From: [REDACTED]
Sent: 12 April 2012 11:15
To: lwrightman@chichester.gov.uk
Cc: Anita Gardner
Subject: The Old Barn - Ferring - Application No. FG/6/12 & FG/4/12/L
Attachments: Drawing 3214-006 Rev C.pdf, Drawing 3214-009 Rev E.pdf, Drawing 3214-010 Rev E.pdf, Drawing 3214-011 Rev D.pdf

RE: The Old Barn - Ferring - Application No. FG/6/12 & FG/4/12/L

Further to yesterday's telephone discussion, please find attachments with Febo Designs revised drawings No's 3214-006 rev C, 3214-009 Rev E, 3214-010 Rev E and 3214-011 Rev D.

DRAWING NO. 3214-010 DRAWN AF SCALE 1:50 A1 DATE April/12 REV. E

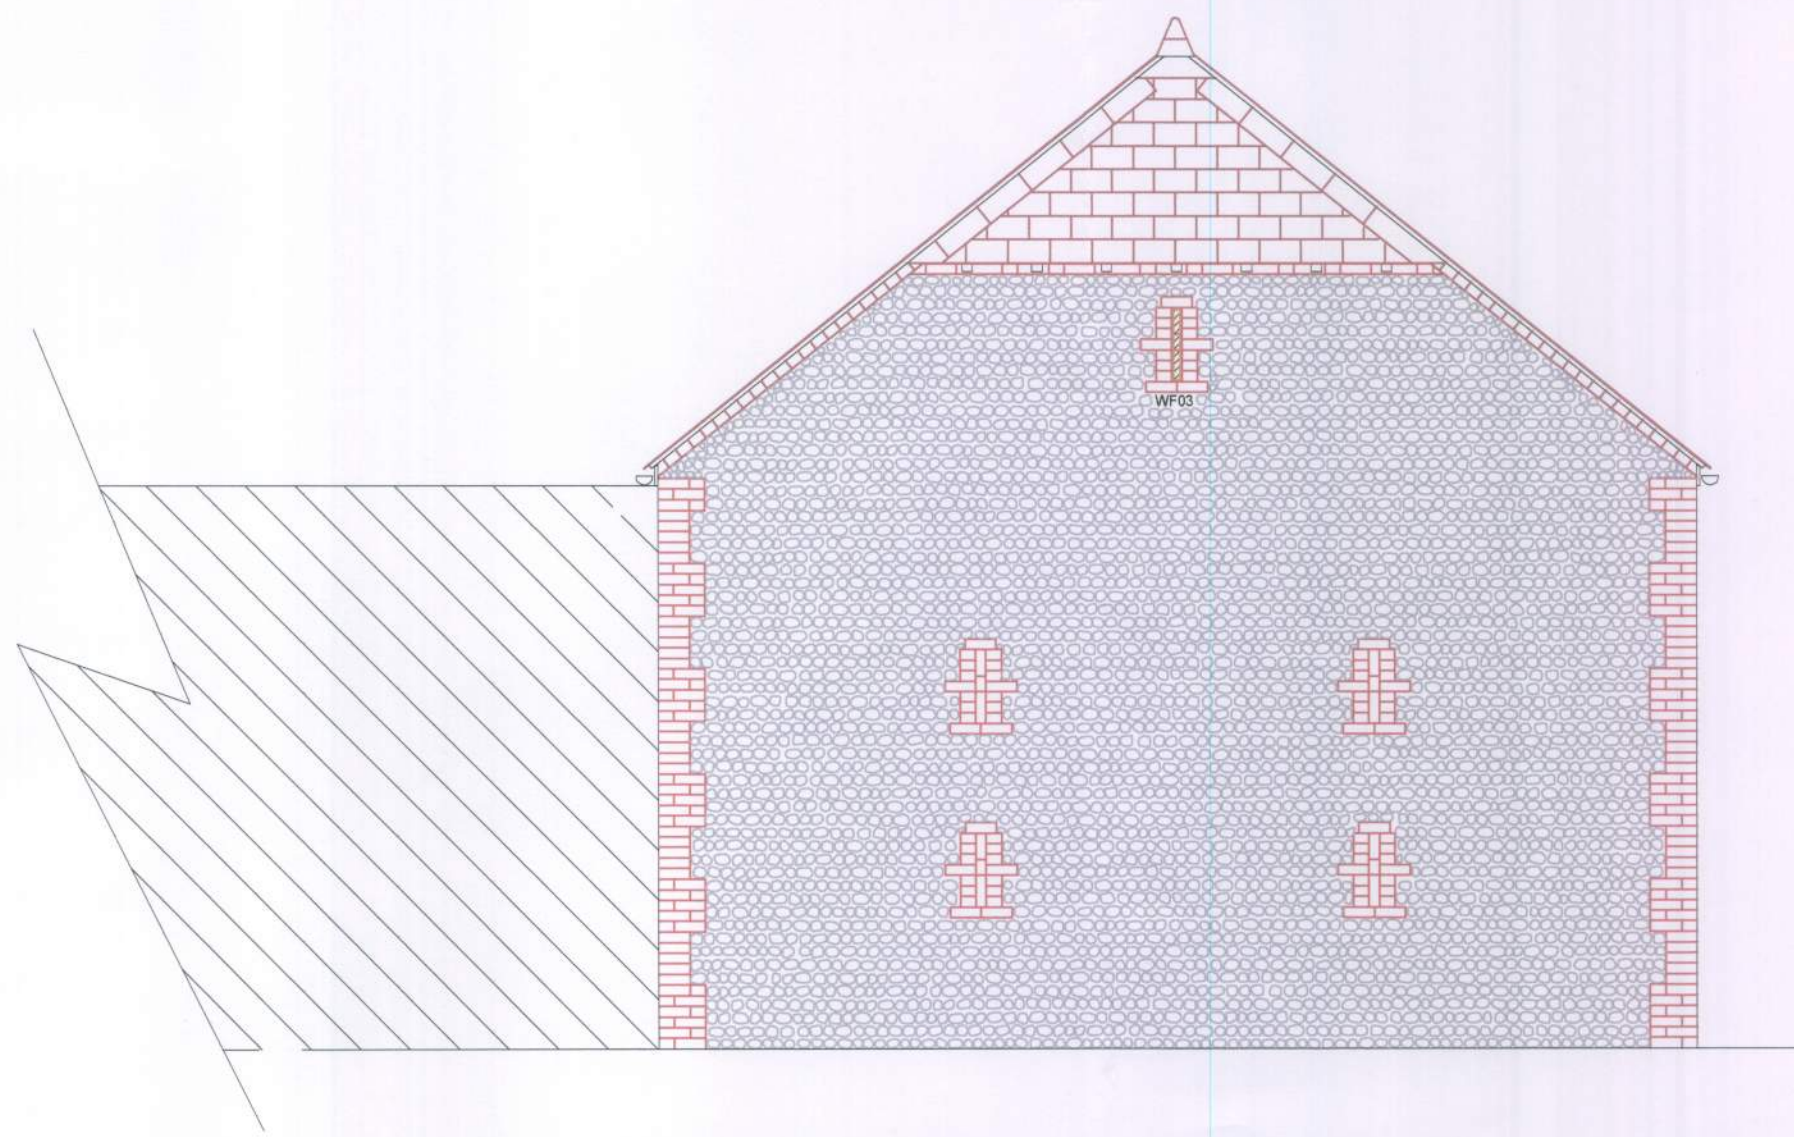
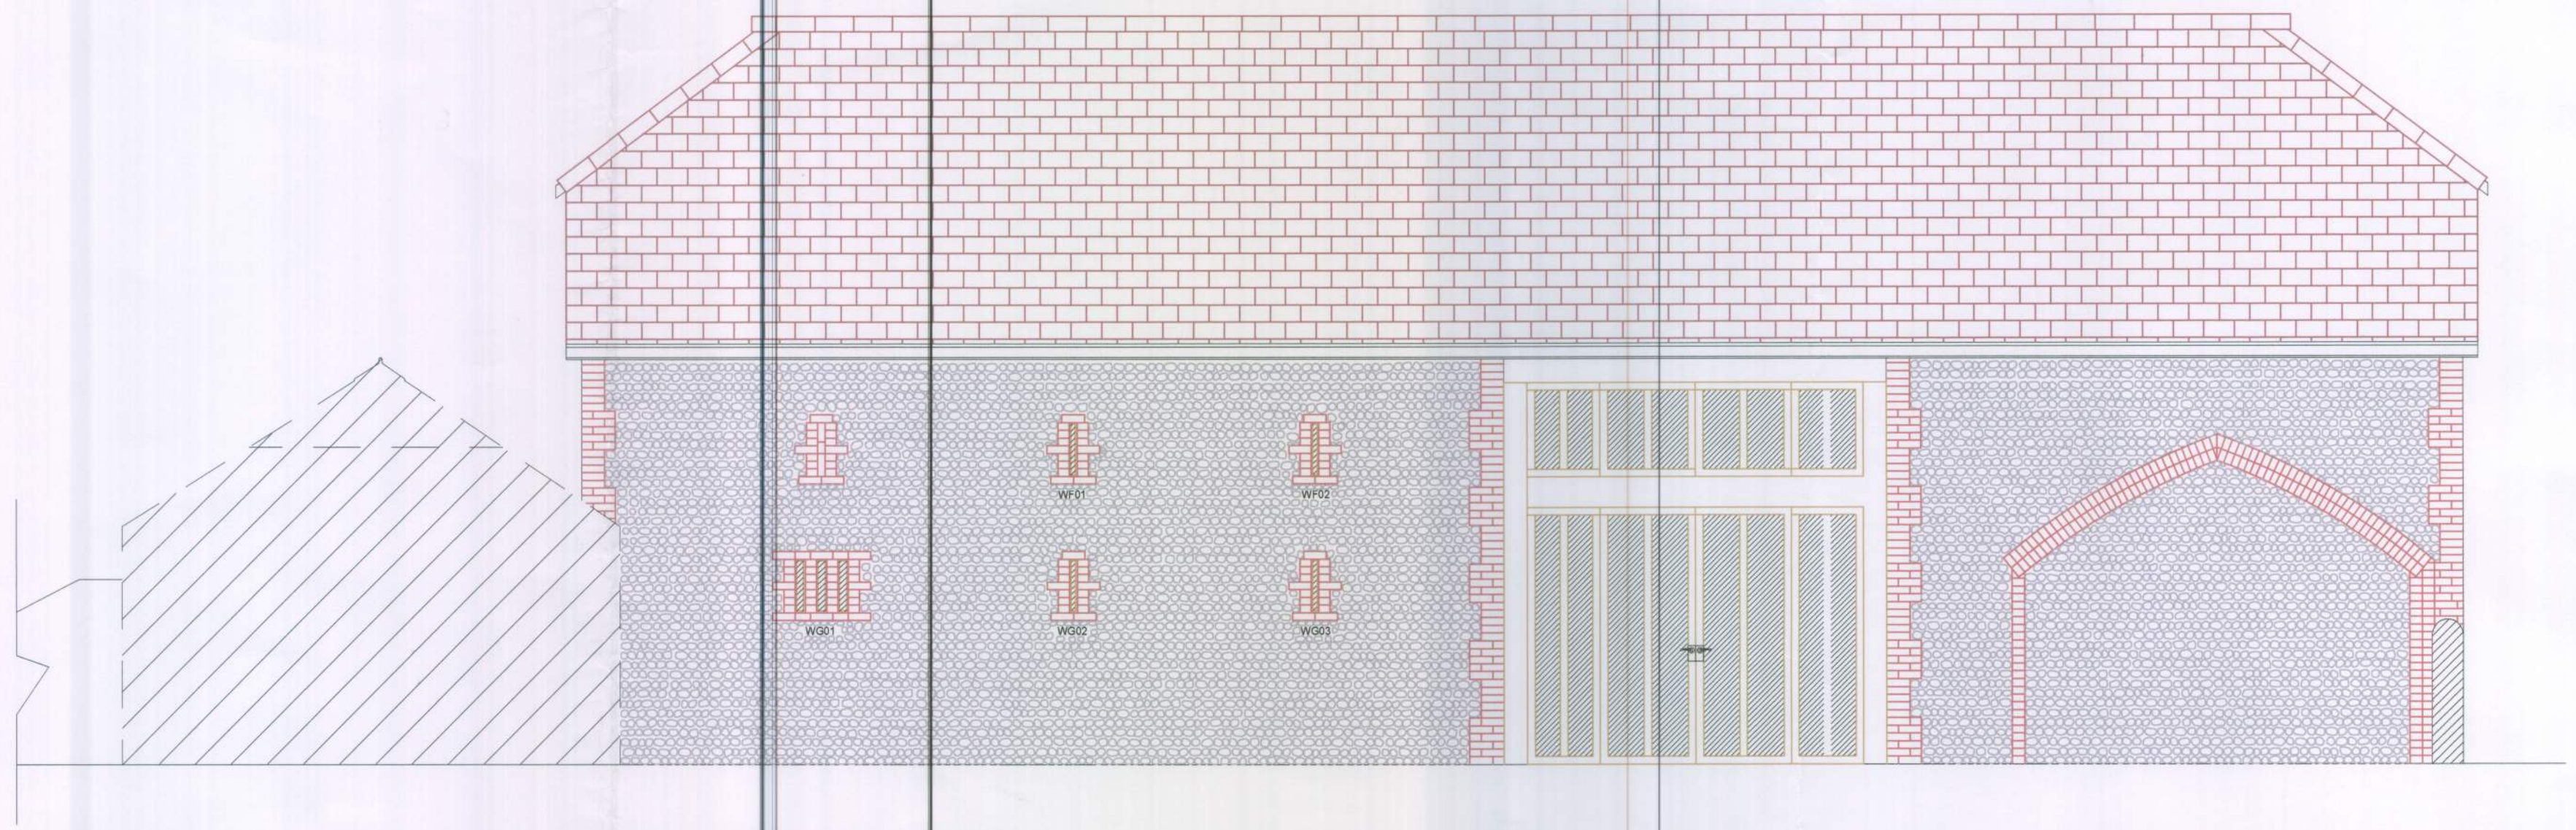
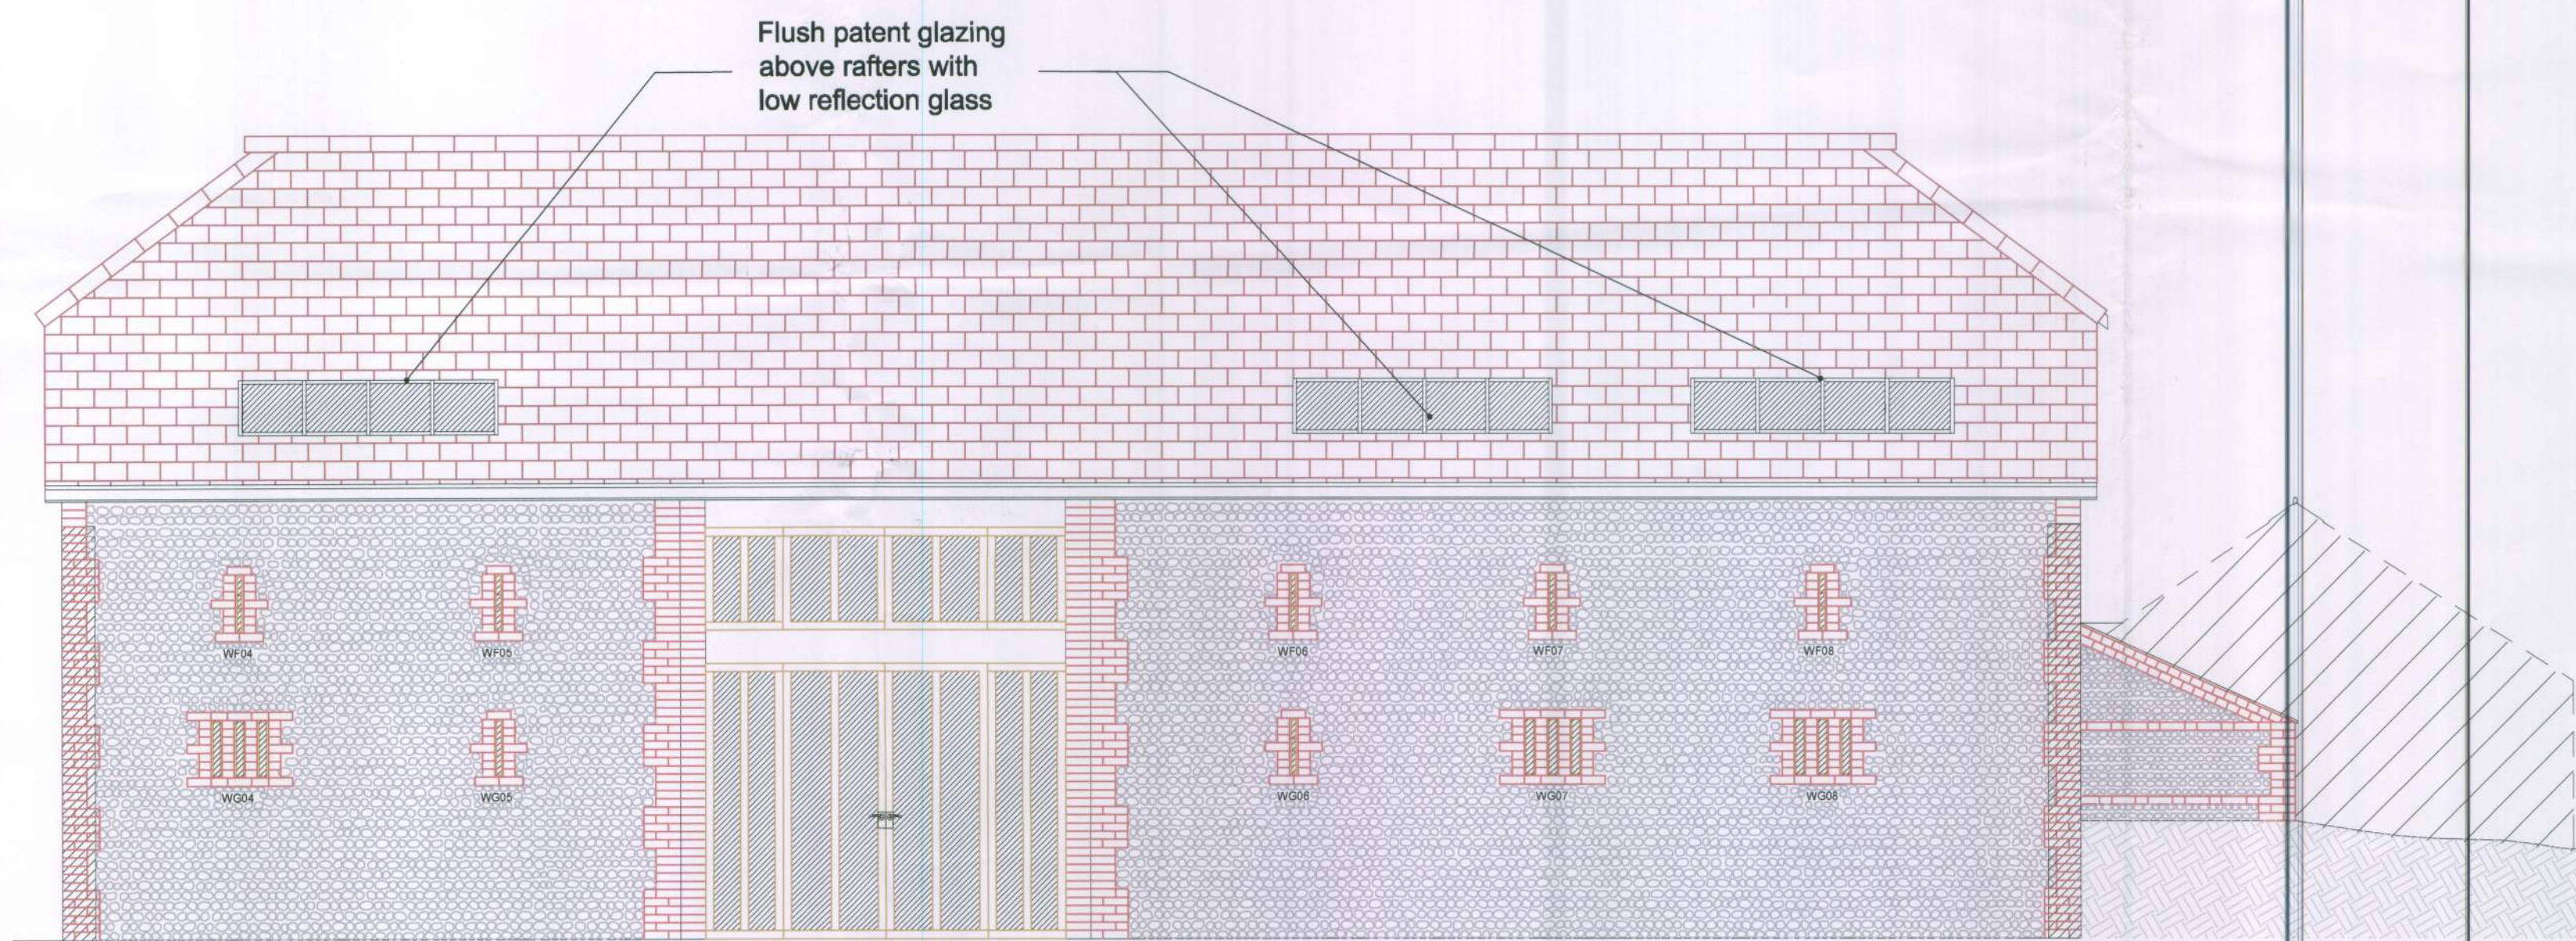
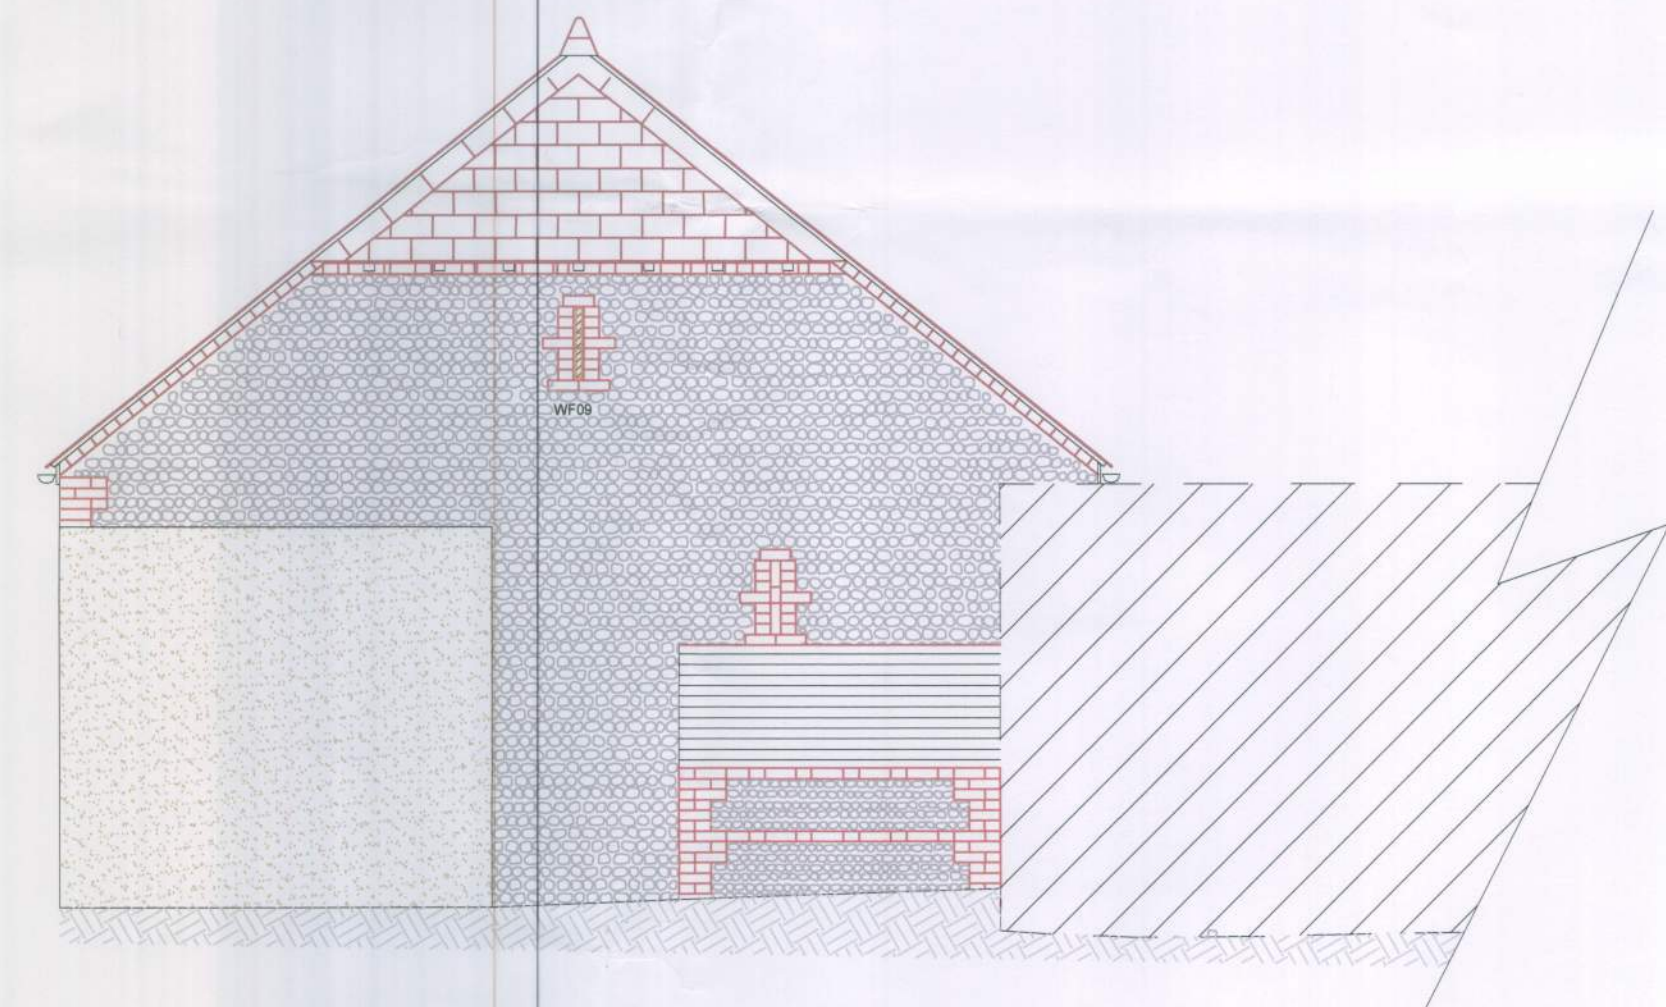
1. The Patent Glazing over the west entrance has been removed
2. The internal glazing to Bedroom 2 has been extended
3. The Study's partitions have been chaged from solid to glazed construction
